## **SDNP/21/05677/FUL**

Address: Tichborne Arms Riverside Farm Lane Tichborne SO24 0NA

Proposal: Replacement rear covered area and relocation of existing vehicular access to existing parking area

Name: - WCC Landscape

DRAWING NO. **979-D-101** REVISION

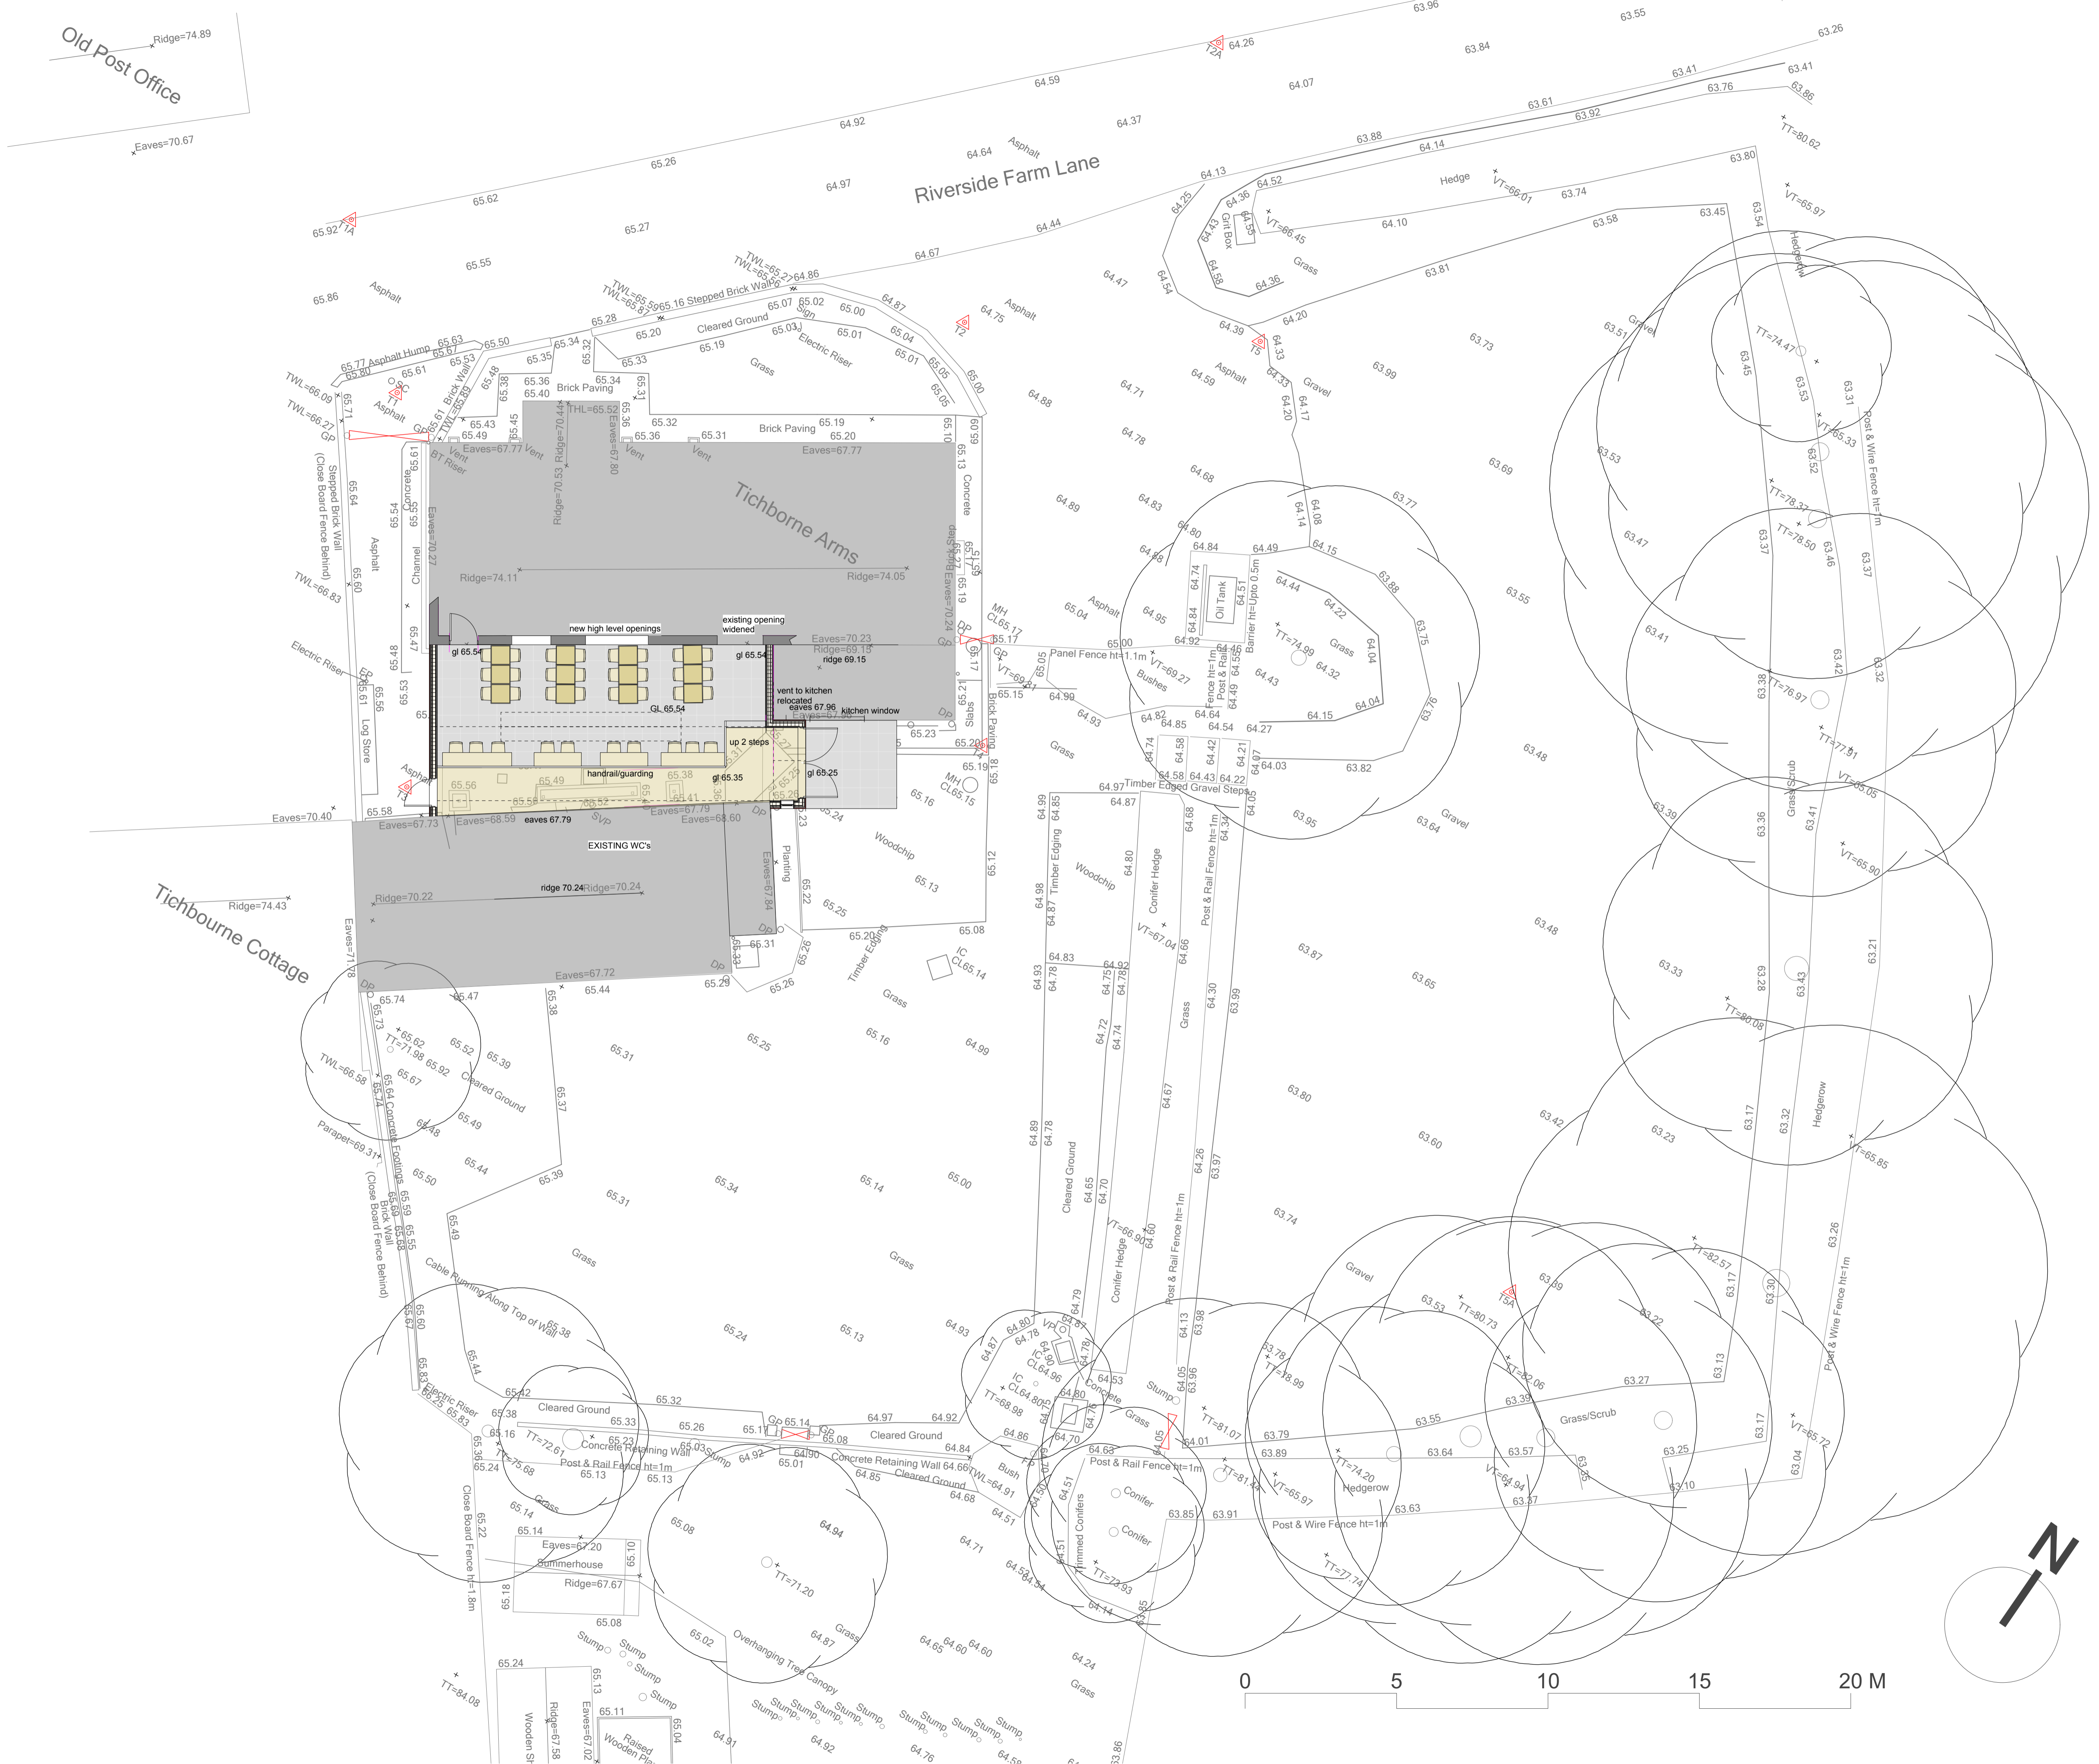
In order to provide the new access a section of hedgerow will be removed. Has the applicant assessed the hedgerow against the criteria within the hedgerow regulations 1997?
